re: **Geotechnical Review – Grading Plan Review**
Proposed Cart Storage Facility – Stonebridge – Phase 16
2701 Longfields Drive - Ottawa

date: June 6, 2022

file: PG4582-MEMO.13

- Project No. 122507 – GRADING PLAN – Sheet No. C-250, dated March 16, 2022.

SHEET NUMBER C-250 **ISSUE** 5

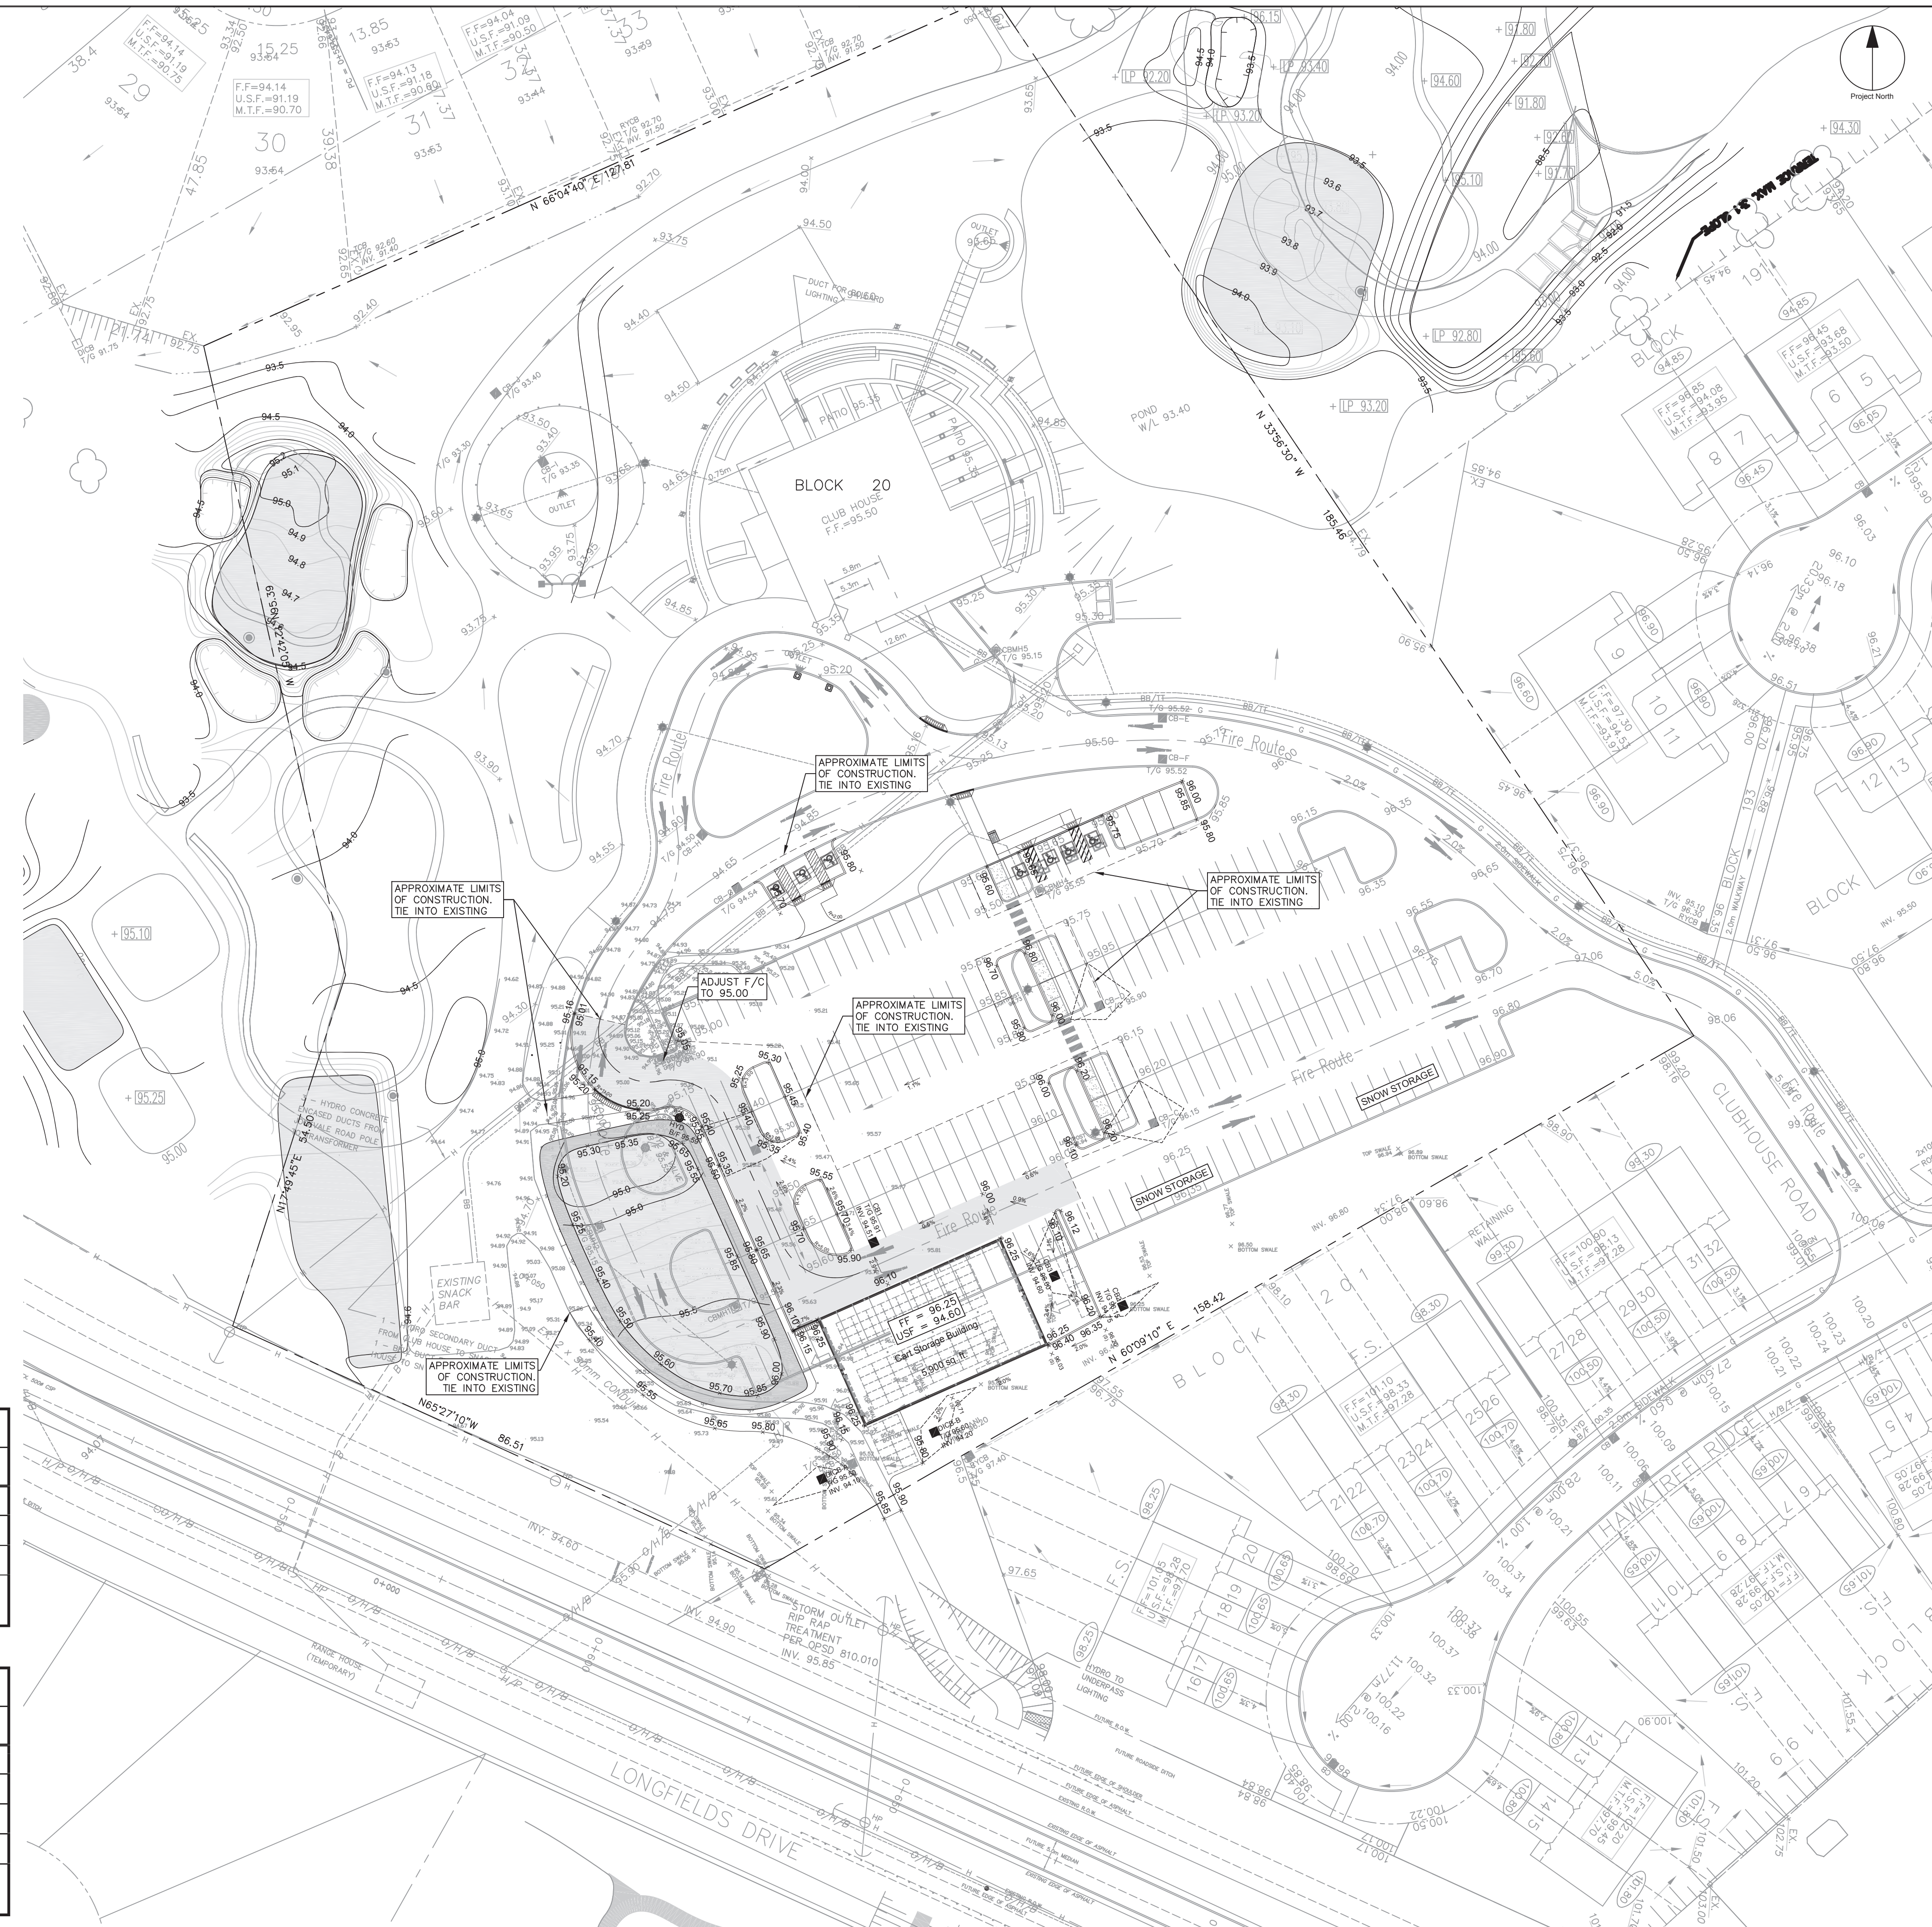
Based on our review, no grade raise restrictions are required for the subject site due to the absence of silty clay deposit. Therefore, the proposed grade are considered acceptable from a geotechnical perspective and in general conformance with the recommendations provided in the above noted geotechnical report.
